From: [Tom or Jan Ward](#)
To: [Chace Pedersen](#)
Subject: Comments Regarding CU-23-00002 (Outpost)
Date: Friday, December 1, 2023 3:52:31 PM

**CONCEPTUAL SITE PLAN
MULTIPLE PARCELS**

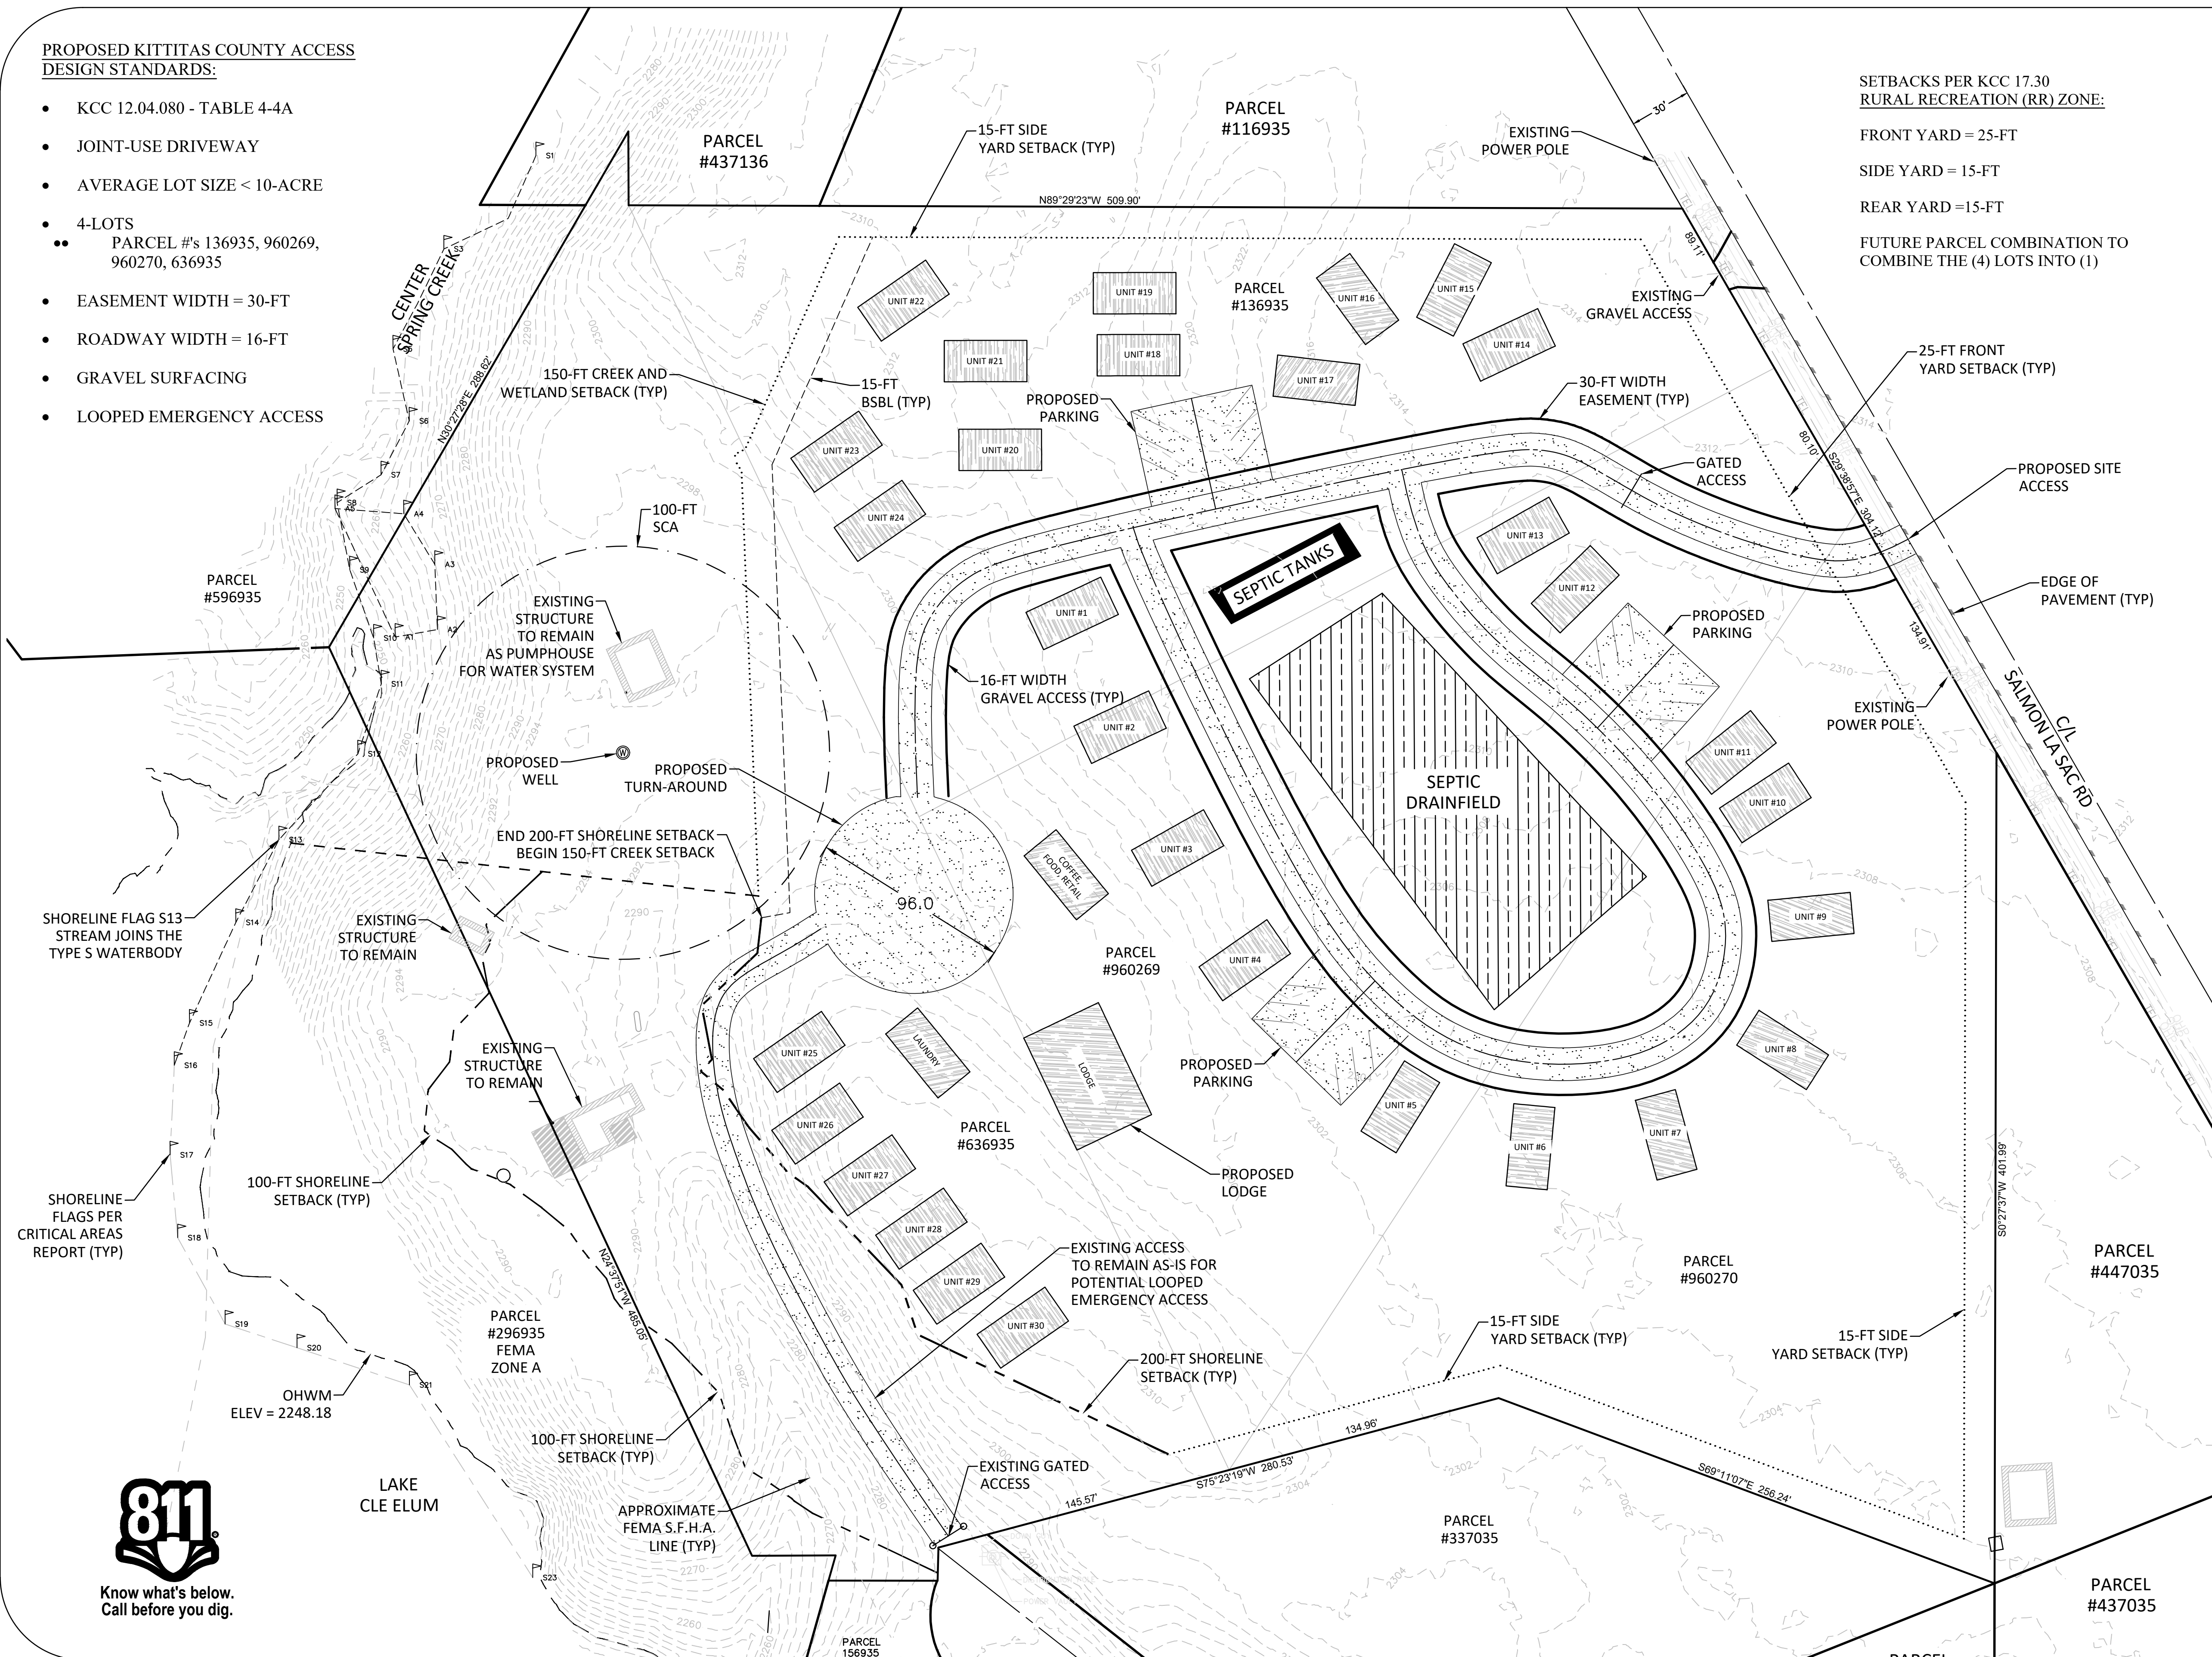
First, I am concerned regarding the vehicle traffic on Salmon La Sac Road. Adding an additional private Campground with 30 spots, adds a lot more traffic and congestion. My concern is that when we had the Jolly Mountain fire, about 5 years ago, we were evacuated from our homes due to the concern that we have only one way in and one way out of Salmon La Sac Road. So add an additional 30 spots in a private campground, I think that would congest our roads further and have safety concerns for the residents on Salmon La Sac Road.

Second, I am concerned regarding our natural resource, water. Lake Cle Elum was so very low this year, we were on water restrictions in our area due to the levels of our wells. So, on that note, will adding 30 more private camp spots and a Club House add to the current water issues?
